Application for a Non-Material Amendment Following a Grant of Planning Permission

Non-Material Amendment(s) Sought

Professor Side Elevation.
(South).

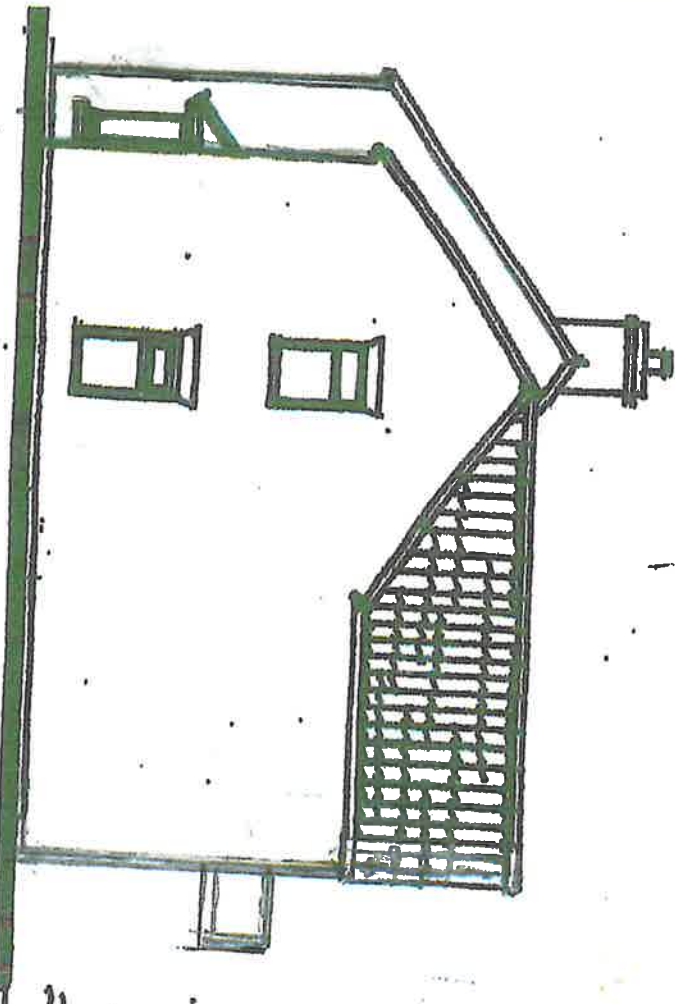
- 1) To correct the side elevation originally submitted as not to correct scale and error only noticed when send plans to have building regs done.
- 2) Did not realise the opening was not correct on submitted drawings till having building regs/ structural plans done.
- 3) We would like to match our neighbours windows and our current ones on rear of property.
- 4) We meant to correct drawing to have full panel opening in kitchen before plans were original submitted but unfortunately forgot so would like to correct now if possible.

The side elevation error that I noticed when arranging building regs plans been done and would to get it corrected before footing went in just in case there was a problem-advice was there shouldn't be an issue as floor plan measurements have been approved but best to get it resubmitted with correct drawing so that I would be cover.

SCALE 1:100
DATE NO. D103
S/17.

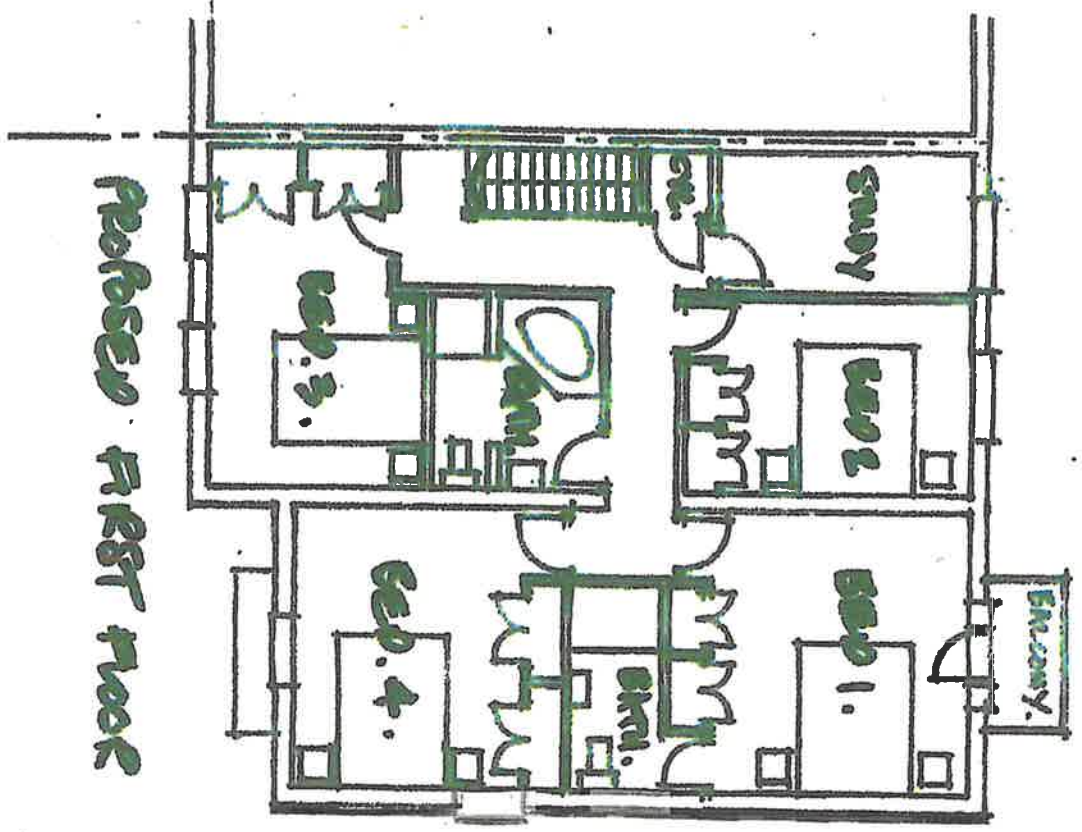
Increasing size of opening for bifold should be ok as not a massive increase but would need to submitted for amendment.

Change of window opening should be ok as windows already there and just changing from part opening window to full opening but would still open at bottom but would need to be submitted for amendment.

SCALE 1:100  
Dwg. No. DHO7A  
10/16.

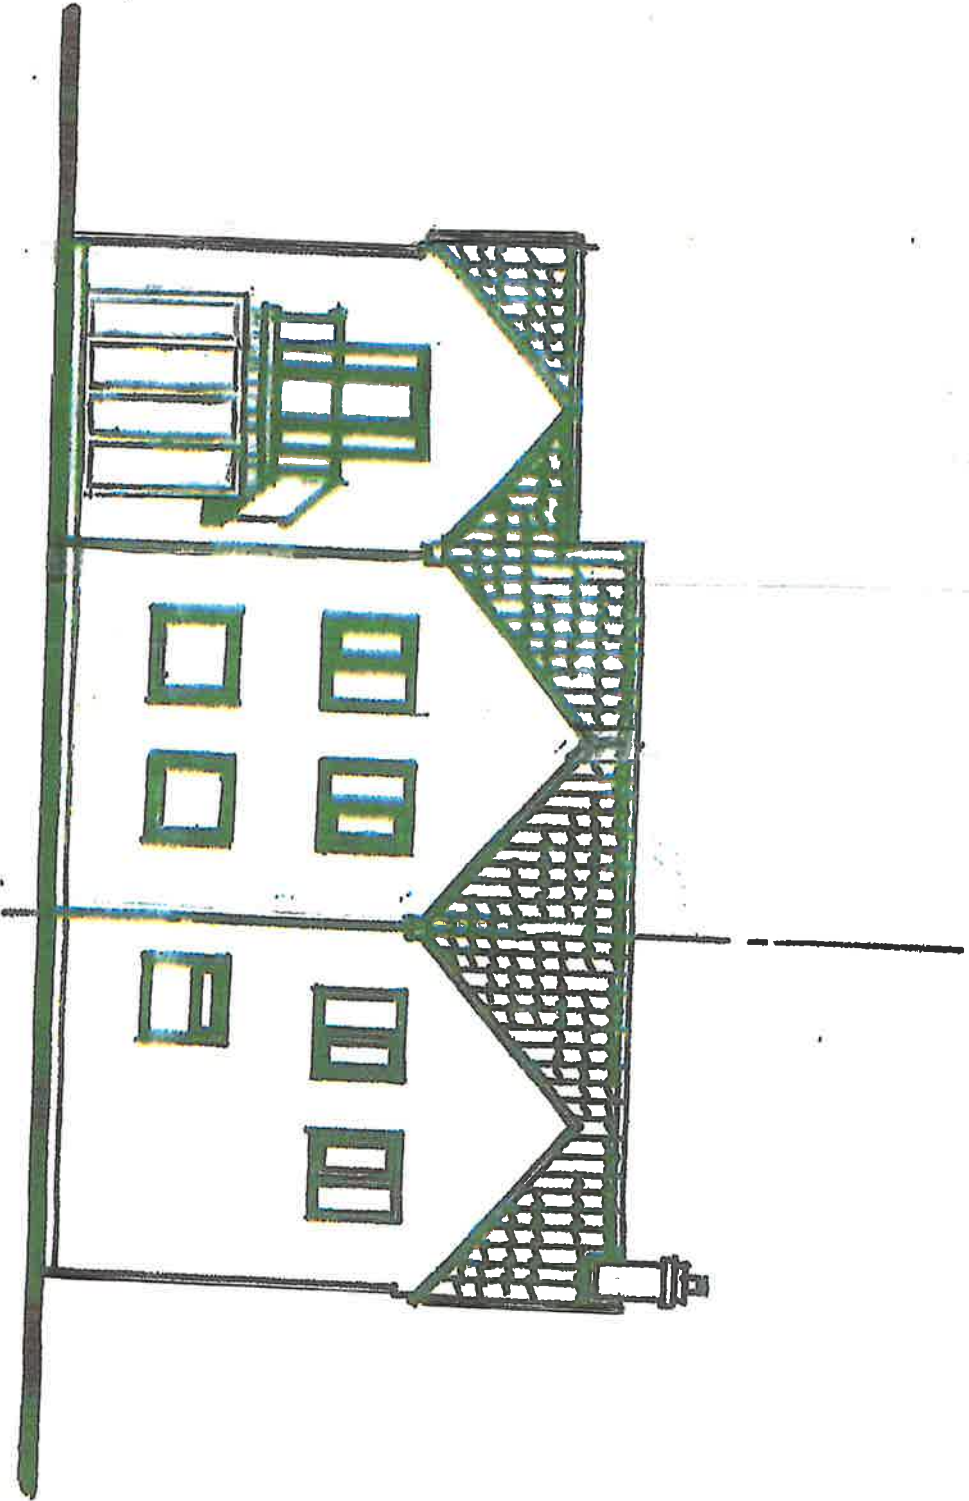
I haven't spoken to any one about removal of decorative lintel on purpose rear elevation as only thought of it when looking at doing amendments as one set of plans that were originally done did not have them but another did and that was uploaded when application was submitted so if possible would like to match neighbours as we have done for front of property
